**City of Portland, Maine - Building or Use Permit**

<b>Permit No:</b> 09-0353	<b>Date Applied For:</b> 04/23/2009	<b>CBL:</b> 424 A014001
------------------------------	--	----------------------------

<b>Location of Construction:</b> 188 PRESUMPCOT ST	<b>Owner Name:</b> OLSON TOLLEF	<b>Owner Address:</b> 188 PRESUMPCOT ST	<b>Phone:</b> 207-671-7946
<b>Business Name:</b>	<b>Contractor Name:</b>	<b>Contractor Address:</b>	<b>Phone:</b>
<b>Lessee/Buyer's Name</b>	<b>Phone:</b>	<b>Permit Type:</b> Change of Use - Commercial

<b>Proposed Use:</b> Food processing & packaging business	<b>Proposed Project Description:</b> Change of Use from single family home to Food Processing and Packaging Business - no construction
--	---

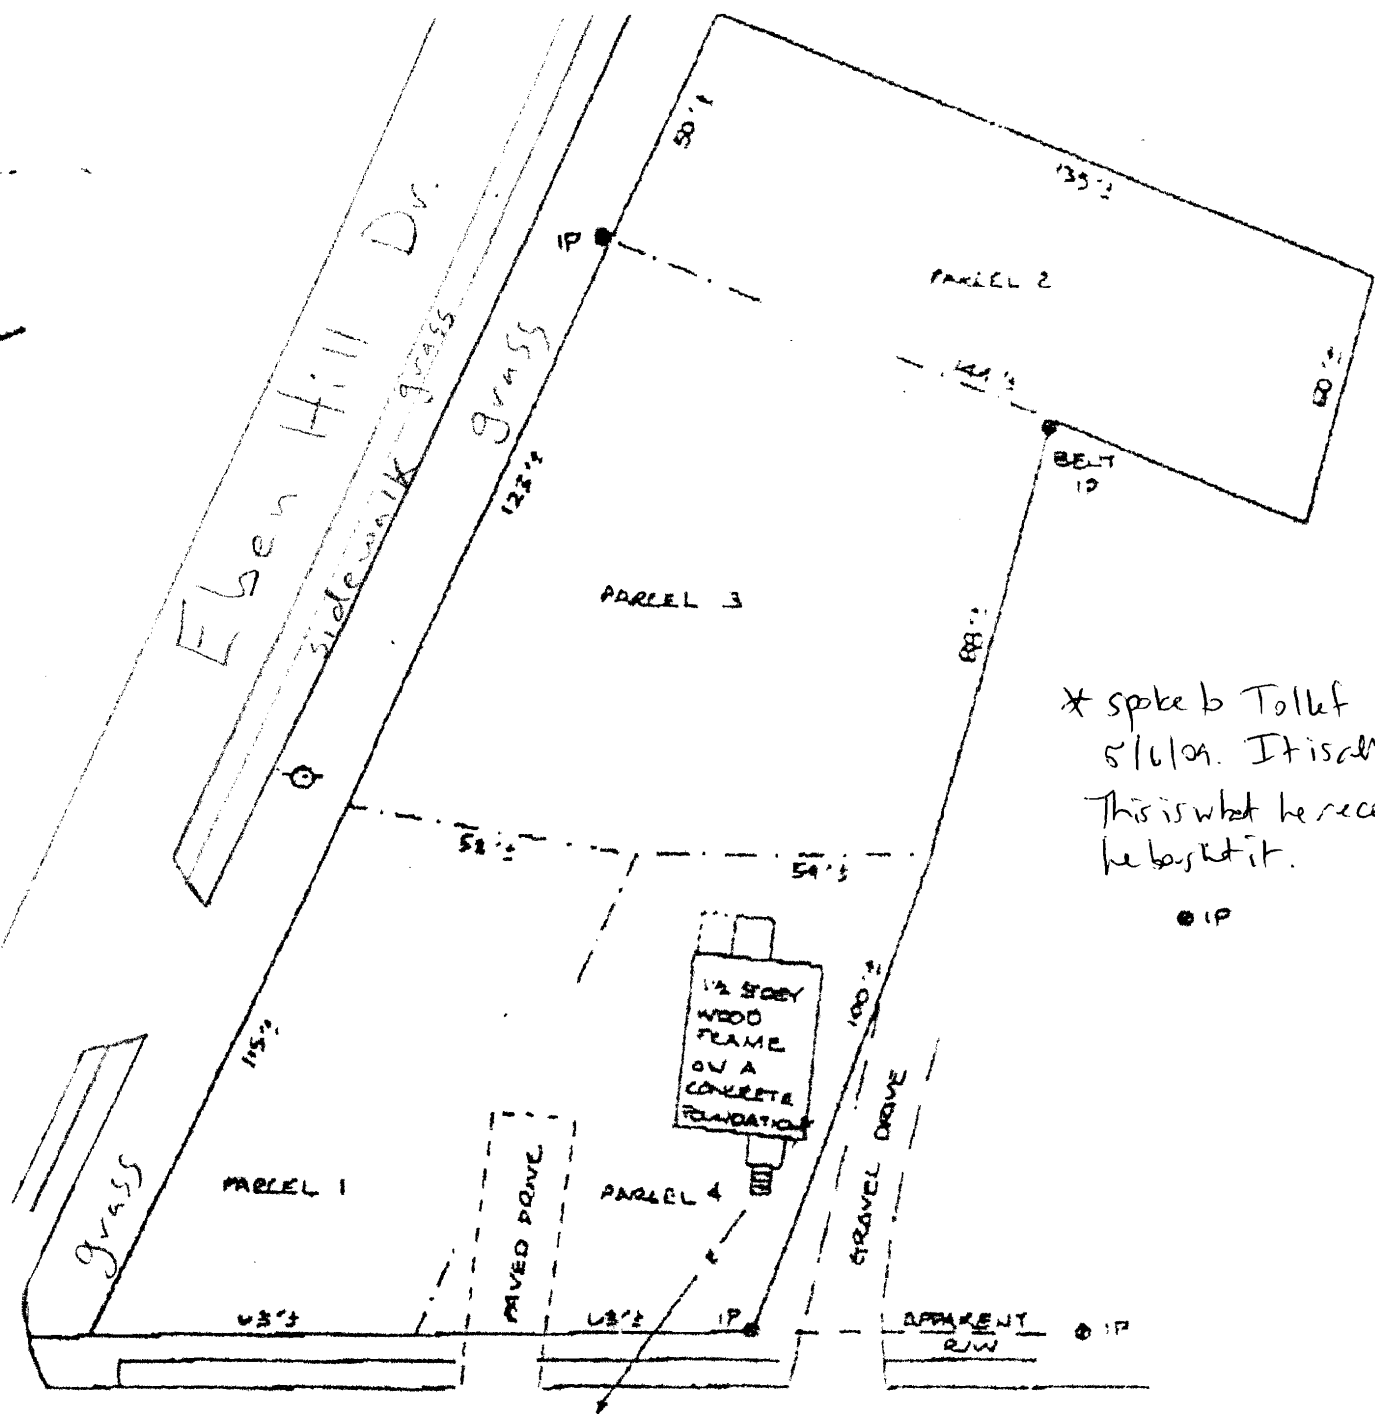
<b>Comments:</b>
<p>5/5/2009-amachado: Left vcm for Tolleff Olson. If changing use to food processing &amp; packaging, why is there a kitchen on the first floor on the proposed plan? Will there be anyone living there? Why does the plot plan show 4 parcels? Assessing has it as one big lot. Single family use is legally nonconforming. Will lose that use once the permit is issued.</p> <p>5/6/2009-amachado: Spoke to Tolleff Olson. The kitchen is just so the employees can prepare food. He said it is not a complete kitchen. There will be no dwelling unit at the building. The plot plan shows four parcels because that is how it came to him. He said that it is one parcel.</p>

\* spoke to Tollef Olson  
5/6/09. It is a more parcel.  
This is what he received when  
he bought it.
